Re: SSI-10051 Sydney Metro - Western Sydney Airport

ATTACHMENT A

Objection is raised to the Project on the following grounds.

Figure 2-1

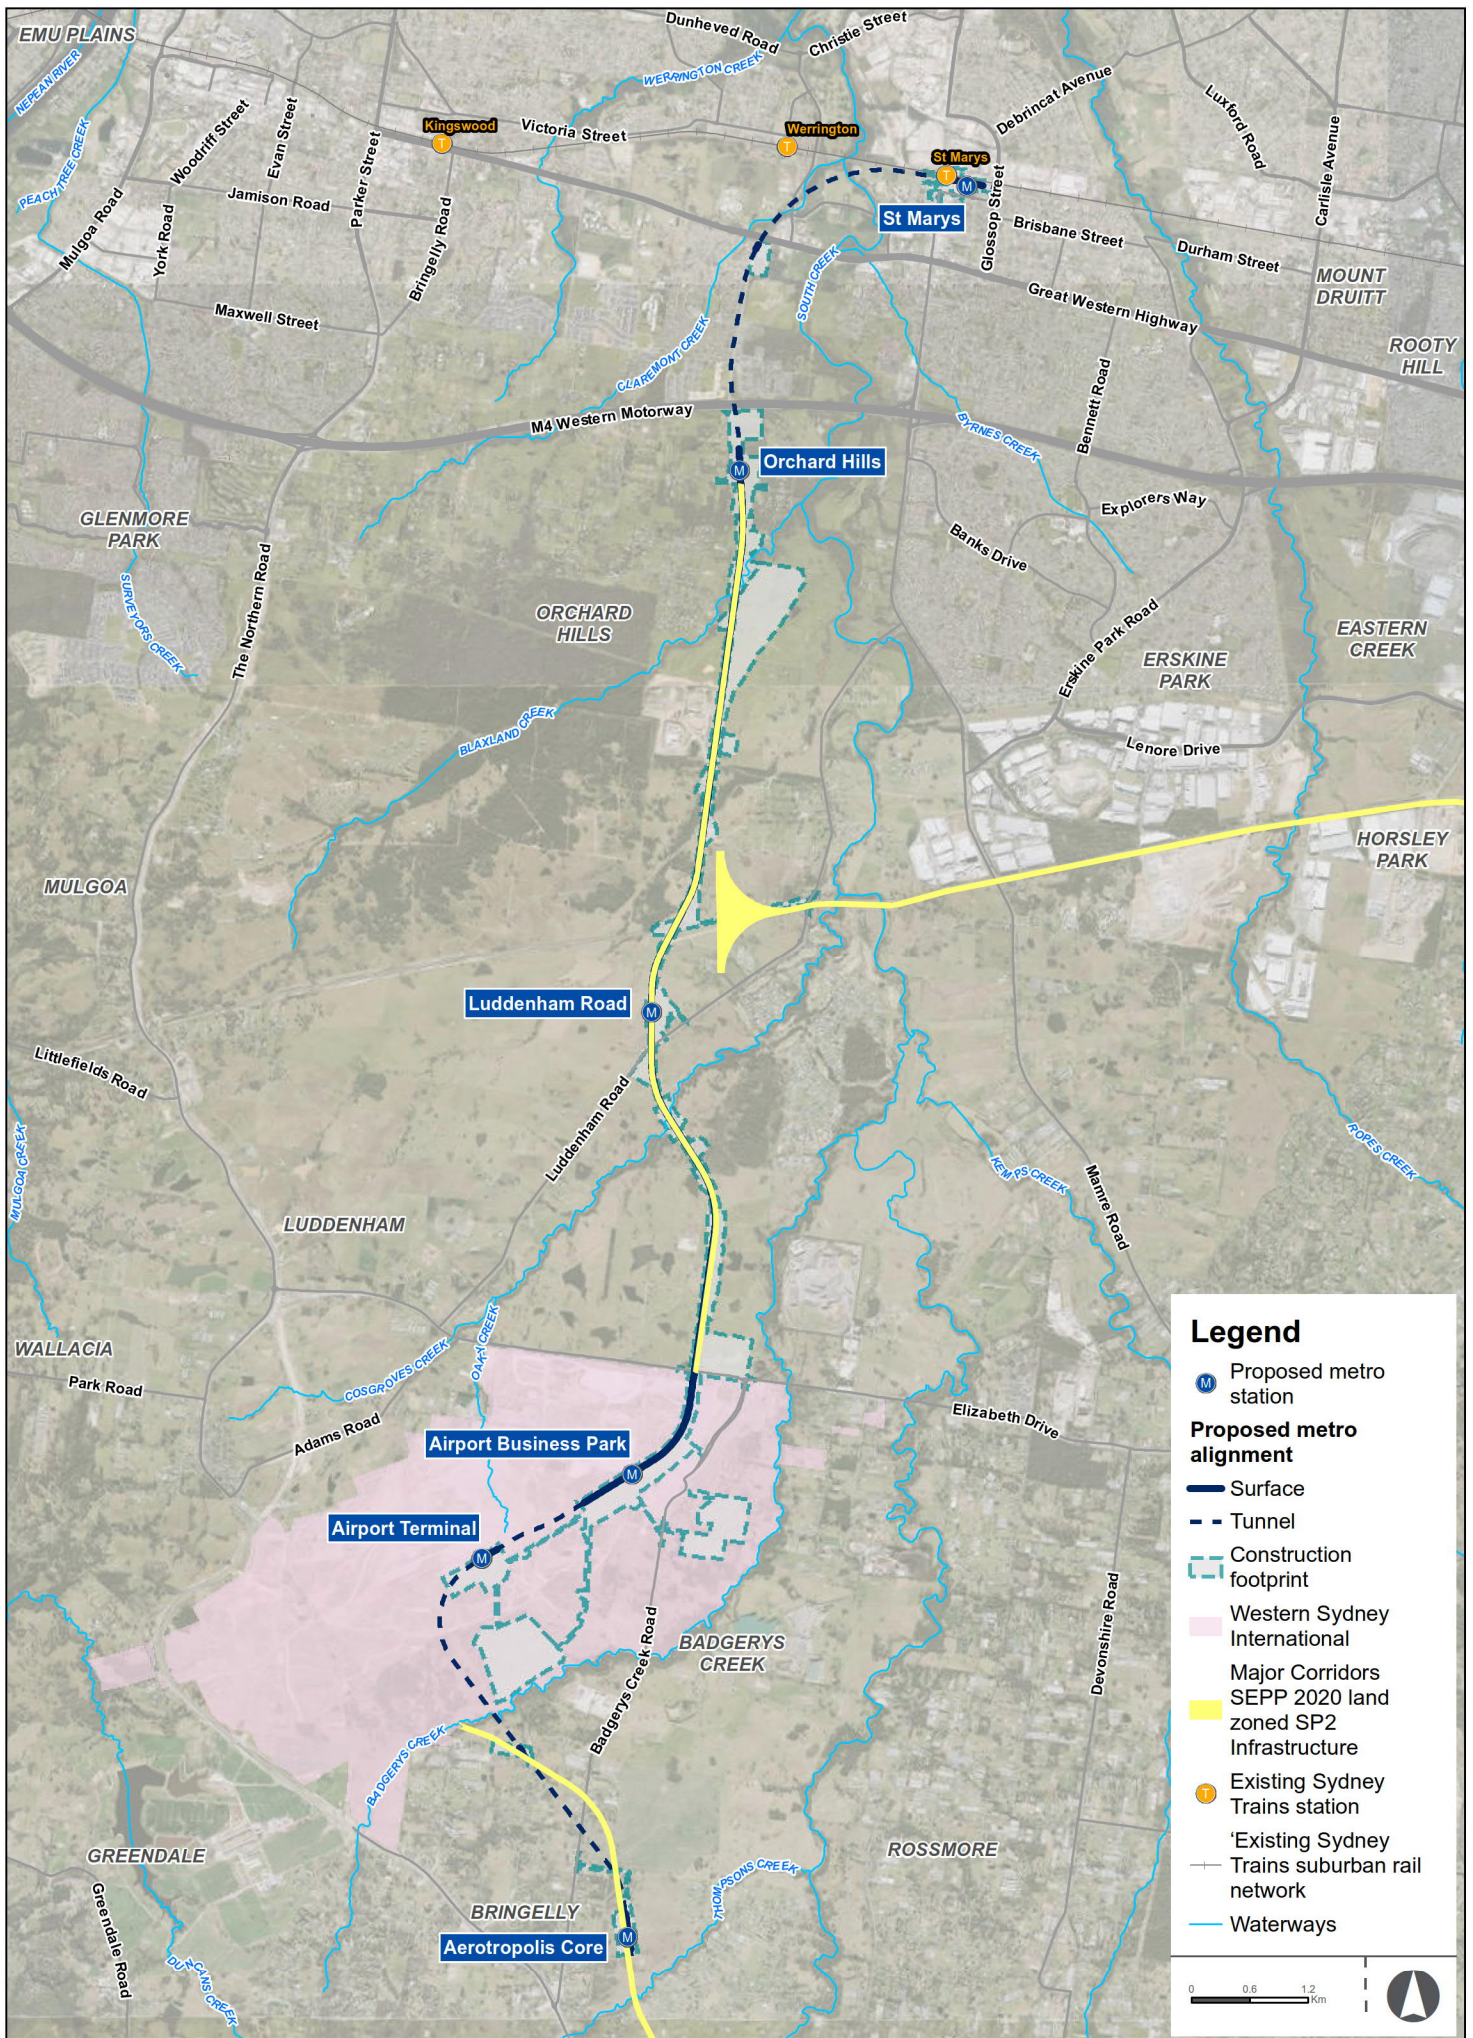
The EIS does not justify the extent of land acquisition, nor the split between (construction) leasehold and freehold. In this regard, the width of the corridor significantly exceeds the corridor zone SP2 Infrastructure under State Environmental Planning Policy (Major Infrastructure Corridors) 2020.
